Local Policing Support Team

RE: Nyton Nursery, Nyton Road, Westergate, PO20 3UQ

Thank you for your correspondence of 5th June 2019, advising me of a 'Residential development of 68 No dwellings (net increase of 23 over current consent AL/102/17/RES, including 30% affordable housing (7 units) with associated access, public open space & landscaping' planning application at the above location, for which you seek advice from a crime prevention viewpoint.

Proposed Street Lighting

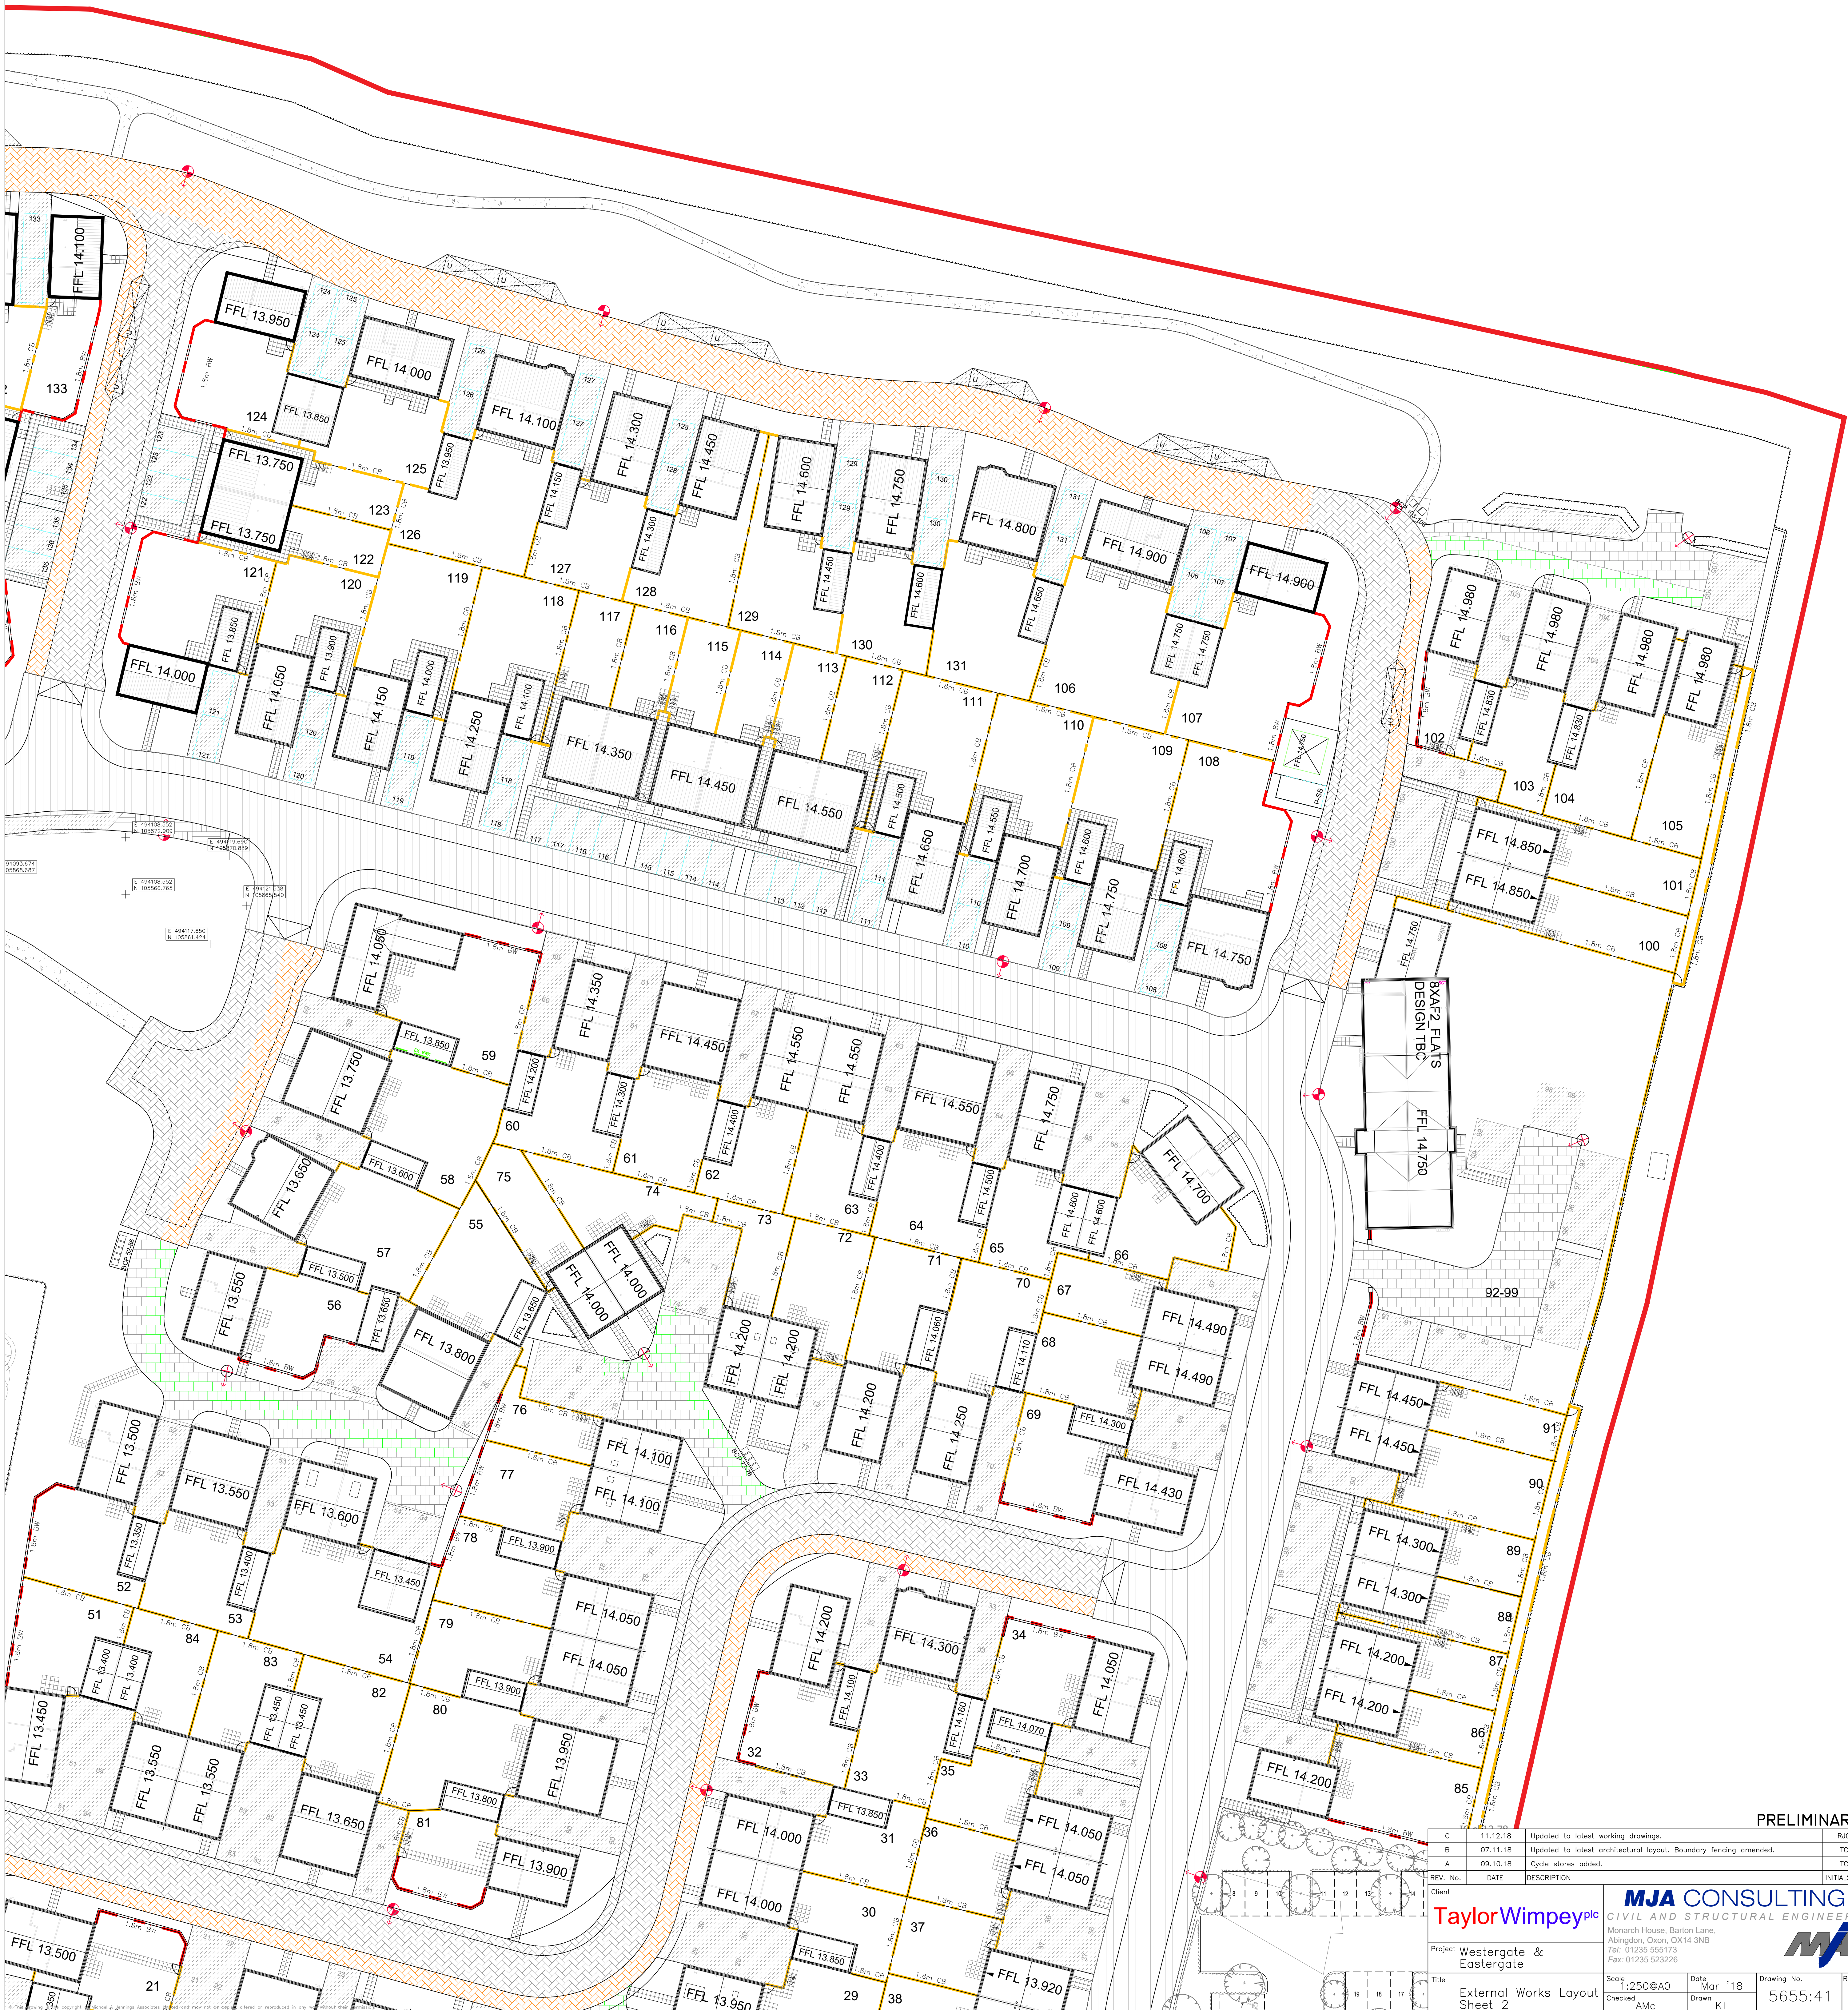
Lighting throughout the development will be an important consideration and should conform to the recommendations within BS5489:2013.
